203 Fore Street

The following initial comment is in reference to the Level III Site Plan application for [203 Fore Street](#).

SITE PLAN LEVEL 02 - MIDDLE STREET  
 1/16" = 1'-0"

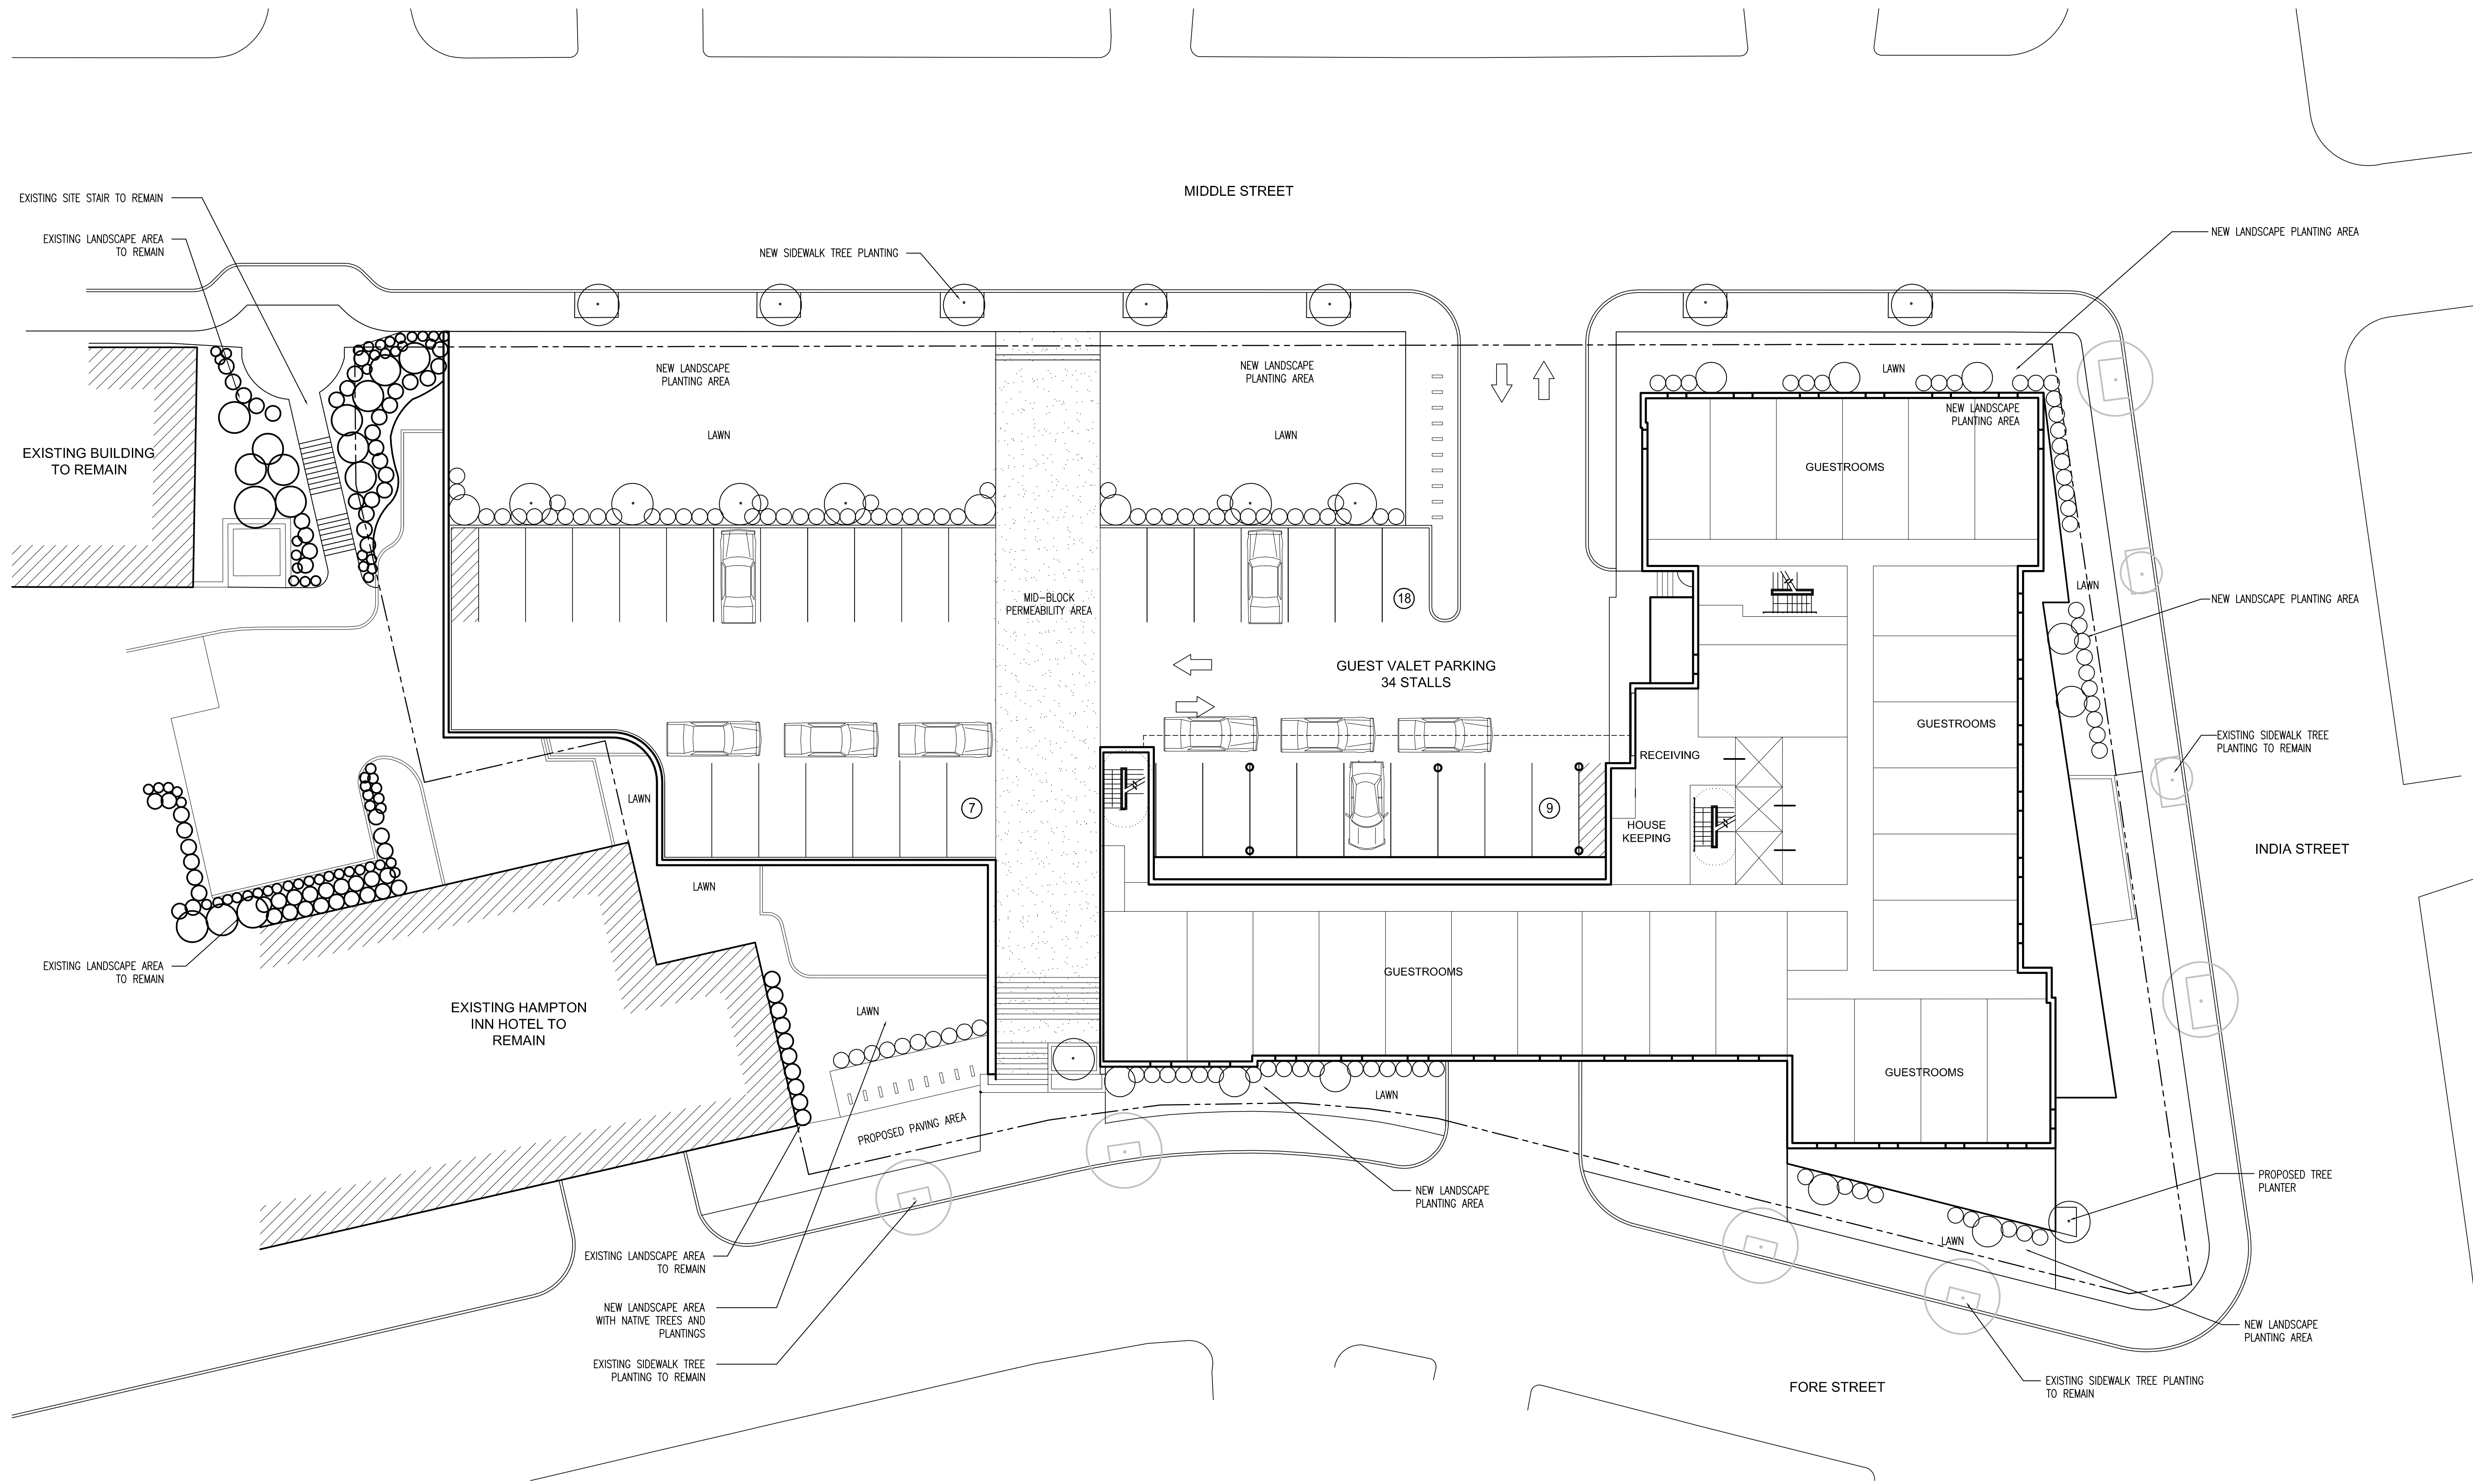
- We have concerns with the proposed parking deck being located over the existing utility easement. In addition to maintenance clearance concerns, the deck corner support would be very close to the existing SD-2 stormdrain. Provide additional information on clearance, deck support footprint and/or stormdrain relocation.
